Recommendation Report for Planning Permission for Works or Extension to a Dwelling

REF NO: EP/19/22/HH

LOCATION: 52 The Roystons
East Preston
BN16 2TS

PROPOSAL: Single storey rear extension, revised dormer and raised garage roof.

Project: Proposed alterations; 52 The Roystons, East Preston BN16 2TS	
Drawing: Elevations as proposed	
For: Mr. & Mrs. Hicks	
Drawn: PKS	Date: December 2021
Scales: 1:100	No: 2881/01/04
To scale when printed on A3

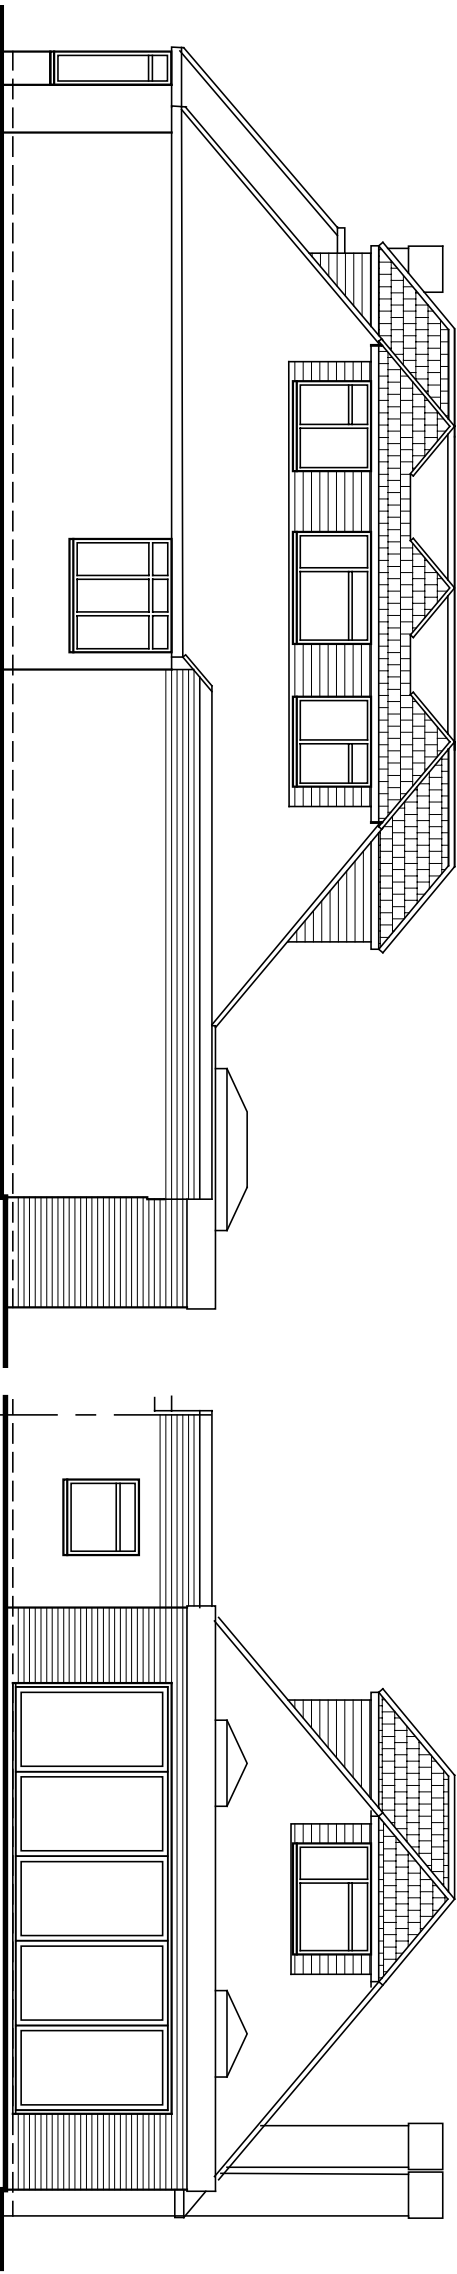
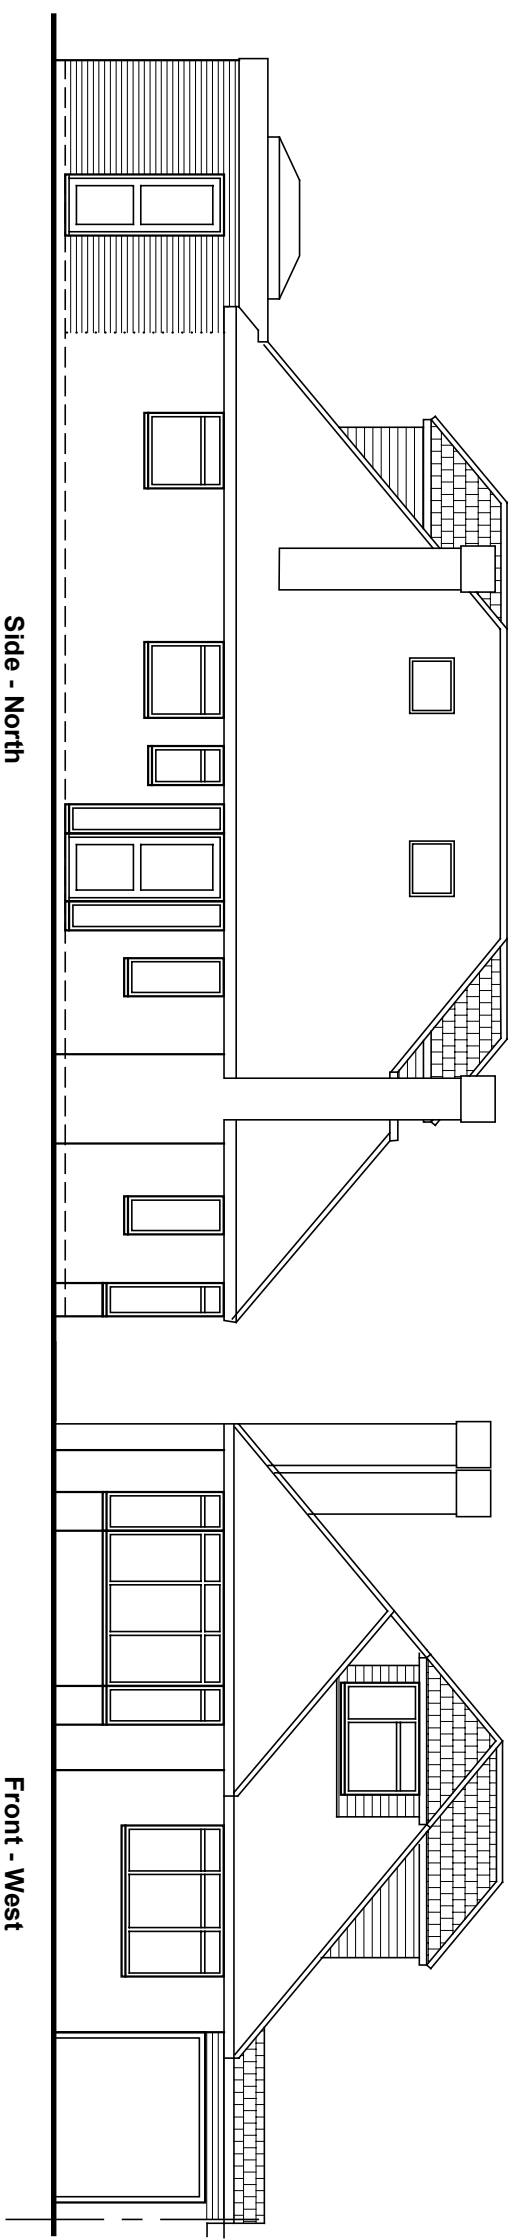
No objection to the rear extension nor to the materials proposed. However, the proposed triple-gabled dormer design replacing the present south-facing flat-roofed dormer, whose ridges spring from the ridge level of the main roof, is possibly over-dominant, as is the proposed front dormer, for the same reason, as it extends the line of the ridge in a manner uncharacteristic of most houses in this close of bungalows. Lower dormer ridges would be acceptable. We are also concerned that the increase in the height of the garage roof will mean that it no longer links satisfactorily with the adjoining garage and would disturb the symmetry of this attractive pair of bungalows.

The extensions are considered to be of an acceptable design and scale, when the prominence of the host dwelling and the site are taken into account. With reference to Section M of the Guide, referencing the design of side extensions. The alterations to the height of the garage, with the inclusion of a small pitch to the front of the garage roof will result in a sympathetic form of development as the alterations appear well integrated with the dwelling, whilst remaining subservient to its built form. This is largely by way of the scaling of the extension being significantly lower than that of the host dwelling and set well back from the primary elevation.

The alterations to the roof include the increase in width of a south facing (side) dormer by approx. 1.2m. The new dormer rather than have a flat roof introduces 3 small pitch/hipped roof sections with small flat sections between. This dormer is visible from the street and will have an effect on its character. The design of the dormer appears slightly awkward however given that it will be constructed with materials which match the host dwelling and to a scale that will be subservient to the host dwelling, it is not seen as a reason to refuse this application.

The two smaller dormers are also appropriately scaled and to be built from matching materials. The rear dormer is subservient to the host dwelling and will not adversely effect the street scene as is considered an acceptable form of development. The front dormer will be an incongruent feature within the street. Other pitched roof dormers are present in the immediate area; however, these are all located to the side elevations. With particular reference to East Preston Neighbourhood Plan Policy 3, when considering new roofs within loft conversions, this addition will conflict with policy as it will extend the ridge line and introduce a new feature to the front facing roof plane, however given that it is an appropriately sized dormer and as the property is located to the top corner of the close, the small negative impact of the dormer is considered acceptable.
